3 October, 2018

Department of Environment and Planning  
GPO Box 39,  
Sydney NSW 2001

**Objection to State Significant Development 8922 (SSD 8922)  
Major Alterations and Additions to Stevenson Library  
Scots College, Victoria Road, Bellevue Hill**

1 View Point 20 Panoramic View East - BEFORE
58 Victoria Road, Bellevue Hill NSW

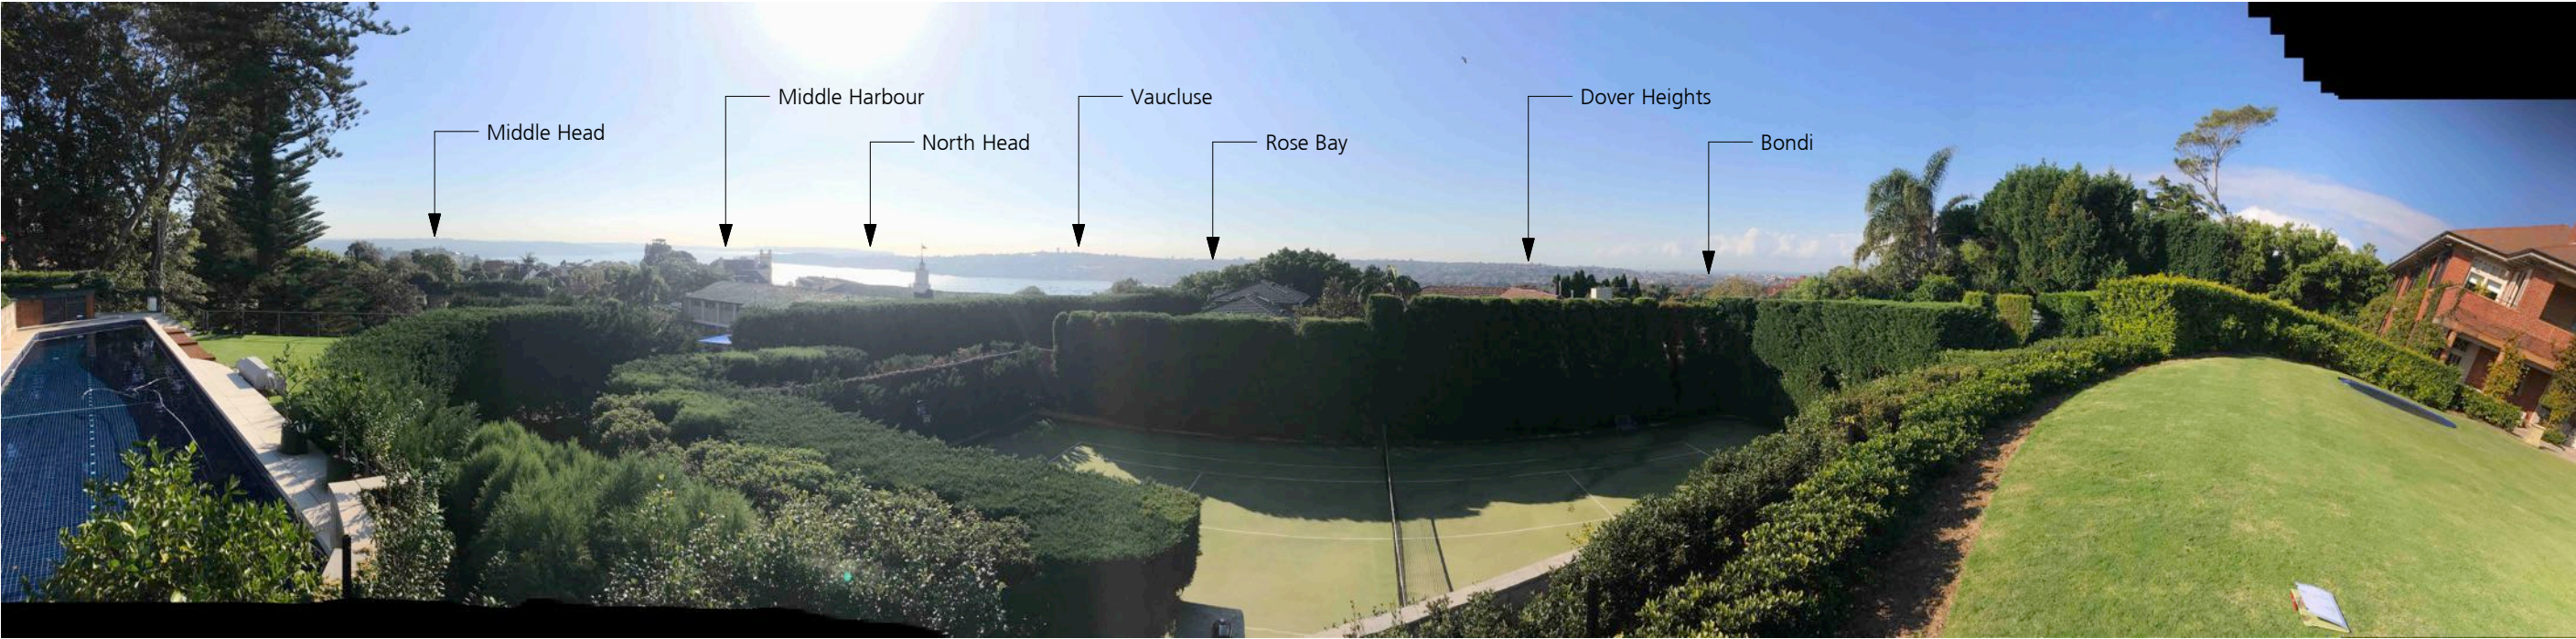
Figure 6 above provides a dramatic representation of the loss of water views and partial landform views due to obstruction by the proposed development. The before image provides a largely unobscured whole water view from Rose Bay to Middle harbour. This uninterrupted view, with the exception of the punctuation by the Middle School clock tower, is highly valuable to the property and its history. Further, it is visible from a sitting or standing position from any portion of the outdoor grassed area.

The after image shows the intrusion of the proposed building effectively halves the expanse of water view from Rose Bay to Middle Harbour.
